28 July 2023

**COMMENTS BY HATFIELD TOWN COUNCIL ON THE PLANNING APPLICATION
6/2023/0456/FULL - 5 WEST VIEW, AL10 0PJ**

Proposed Loft Plan

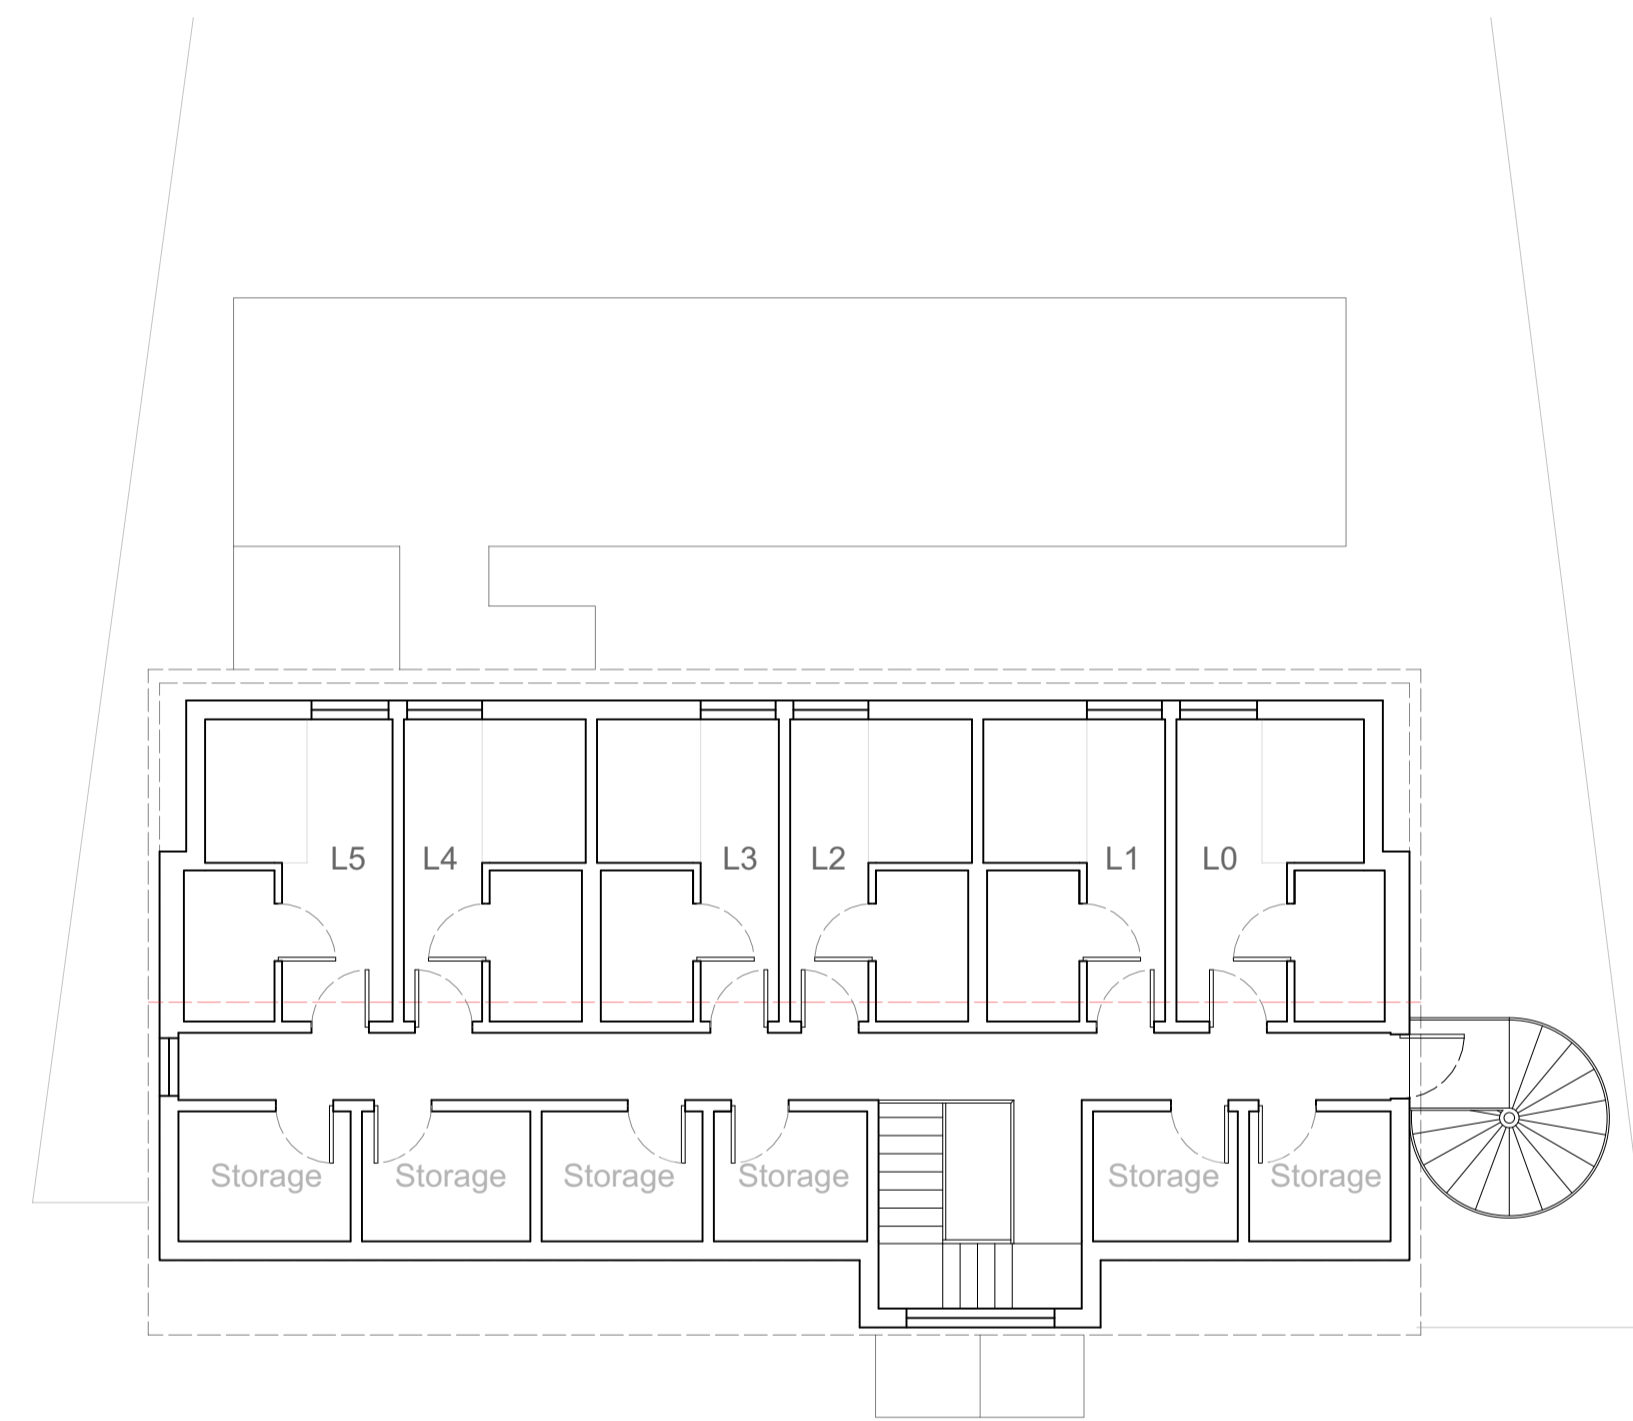
The Town Council noted a number of design issues which, it assess, means the proposal falls foul of Planning Policy D1 and D2 which requires a good standard of design. The proposed top floor extension of the existing building would significantly change the character of the building and setting of the area (which is dominated by two story buildings, with no commercial properties rising to three storeys).

The top floor extension, as designed, has windows looking directly into the neighbouring properties, significantly reducing their privacy. The Town Council assess this to be contrary to the principles set out in Planning Policy D1.

Client: Group PA
Site Address: 5 West View AL10 0PJ
Drawing Number: 009
Scale: 1:100 & 1:500
Project: Development

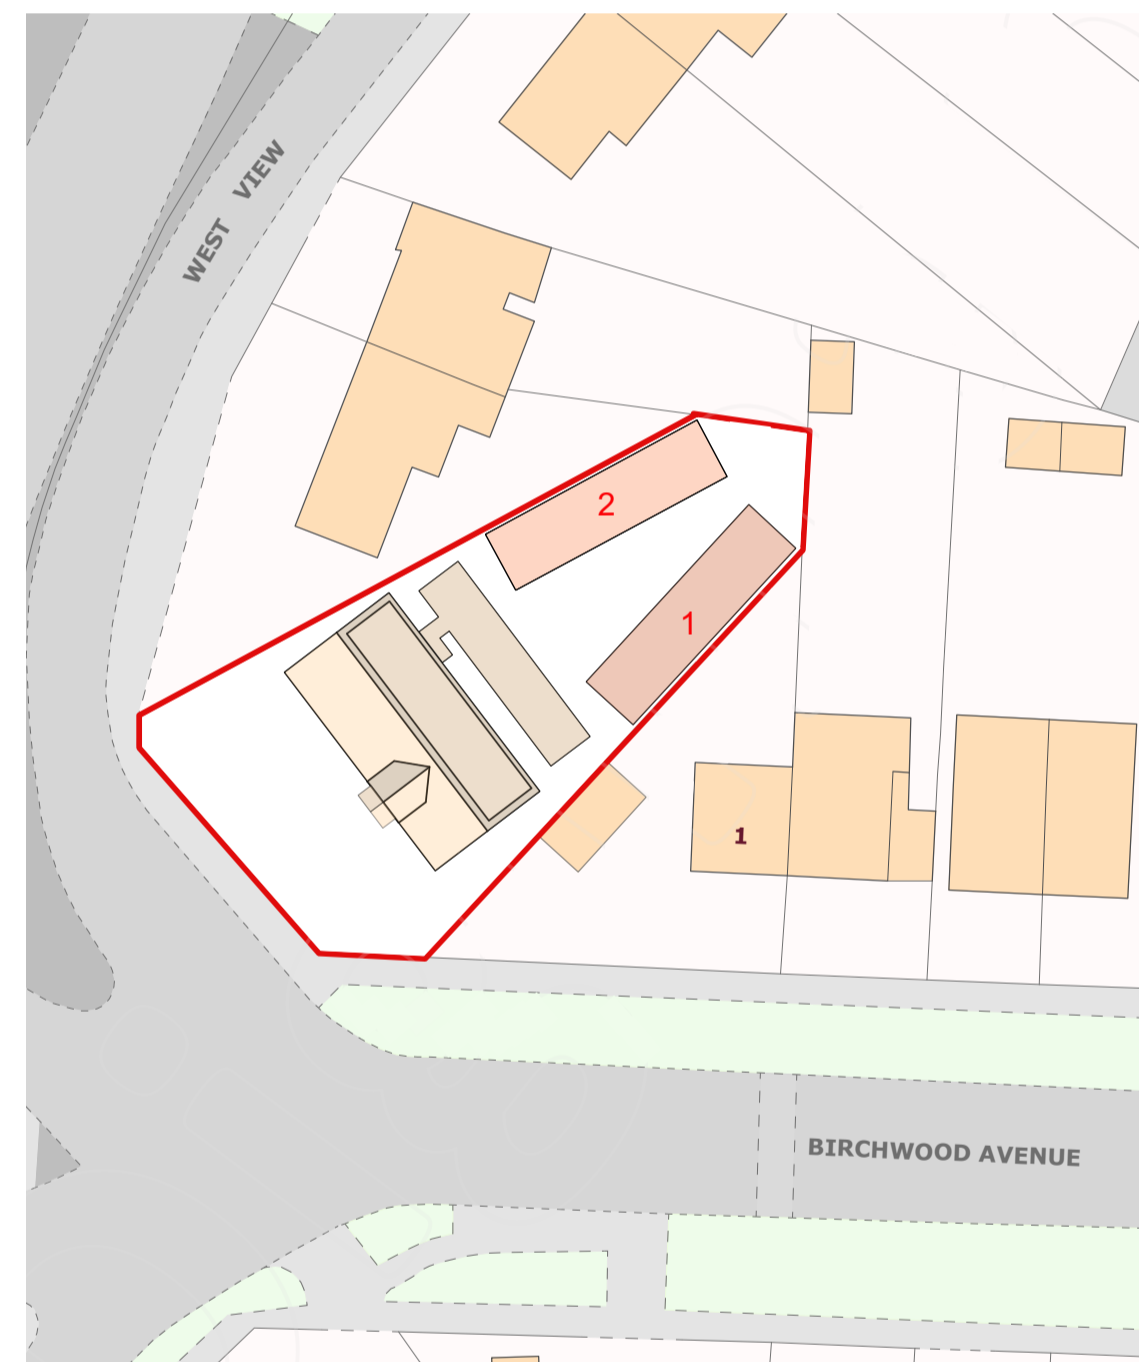
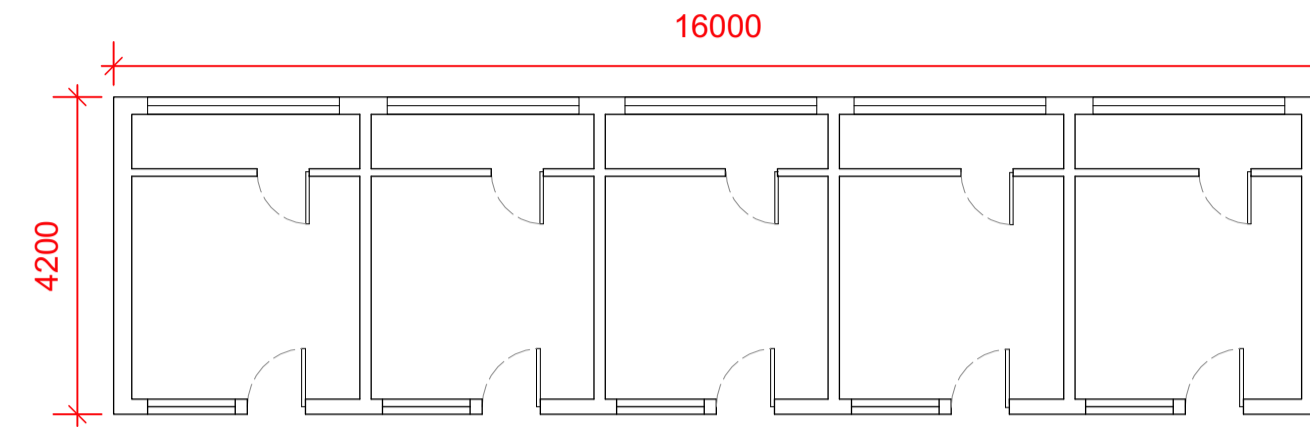
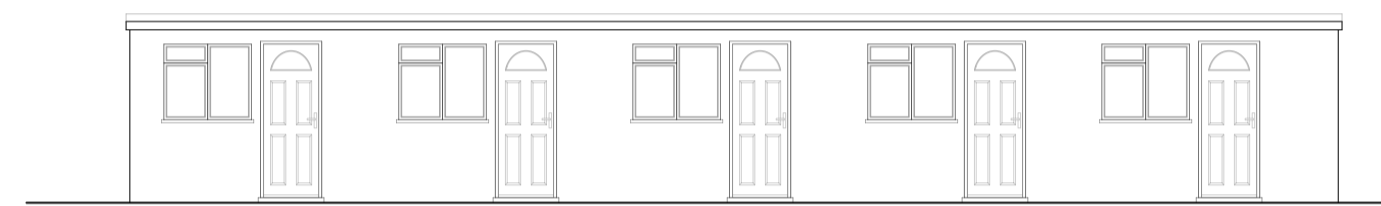
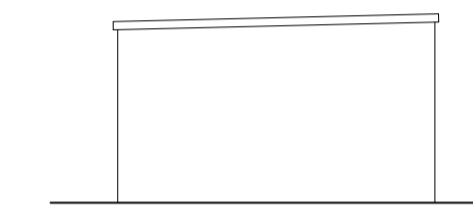
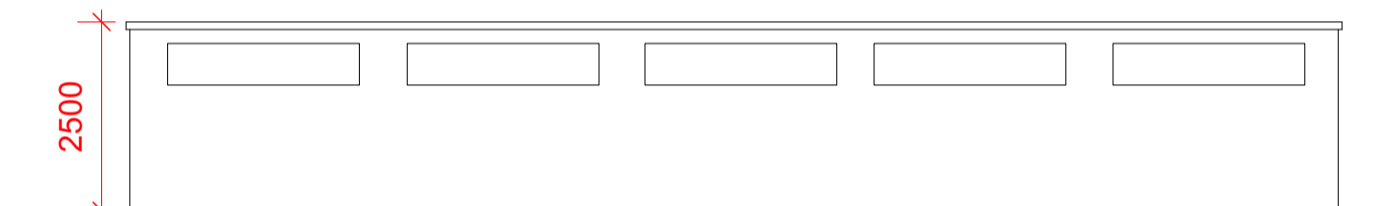
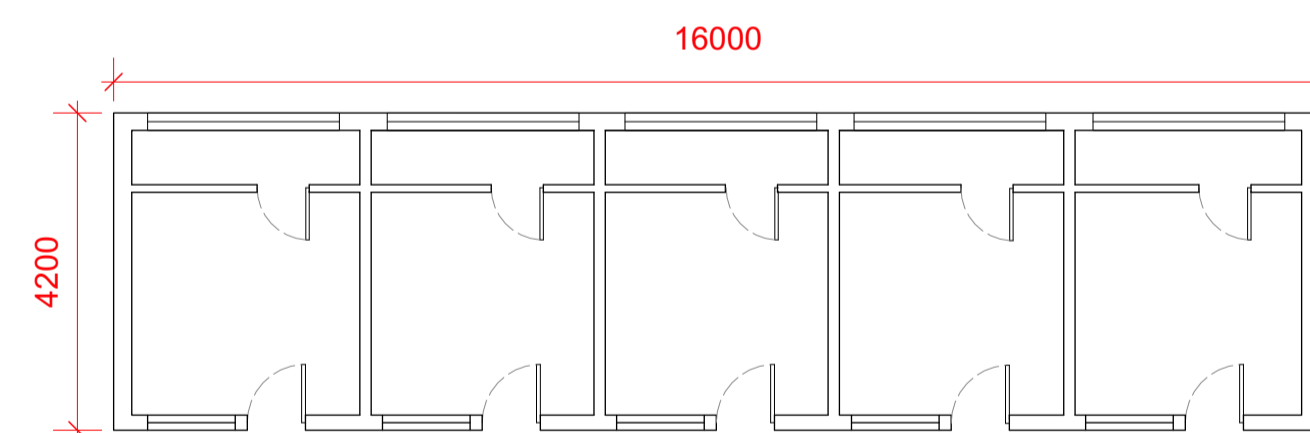
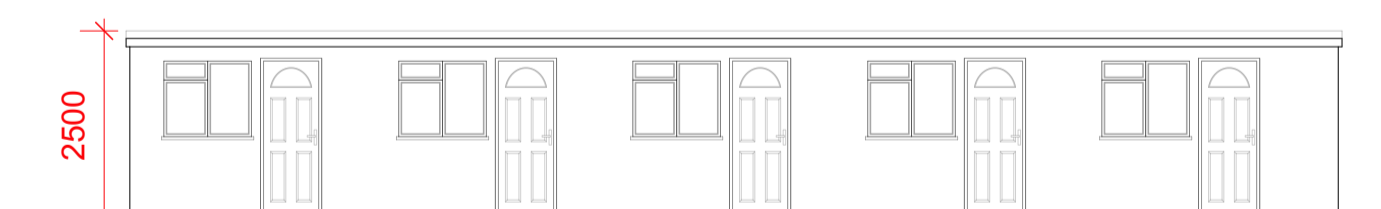
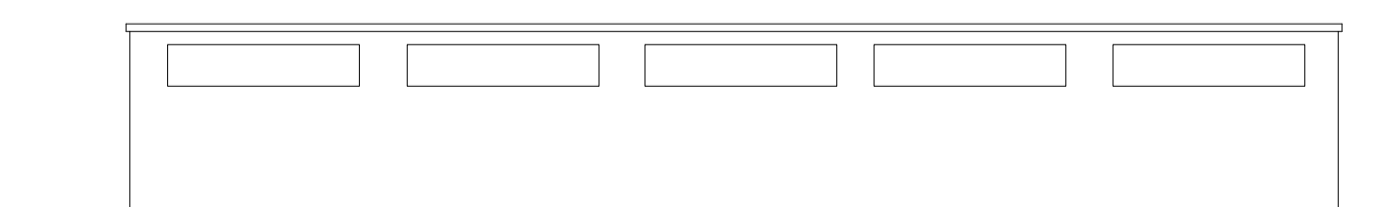
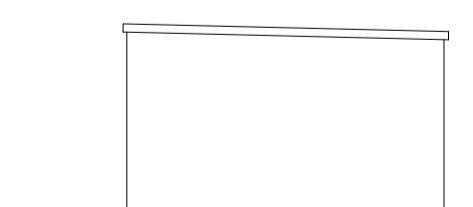
However the application to build two outbuildings is the most concerning aspect of the planning application. As well as being a clear example of overdevelopment for this site, the Town Council assesses the site as being totally unsuitable for the size of hotel that the developer

would like to envisage. As well as adding to the parking issues at this particular site, the envisaged high turnover of guests at this low cost hotel is likely to cause harm to the neighbourhood without adding to the local economy. The development would also create a safety risk as it is not clear whether the emergency services could easily access the rear outbuildings. These rear buildings would also have a detrimental effect on the neighbouring properties. Together this further supports the Town Council's view that this proposal falls foul of Planning Policy D1.
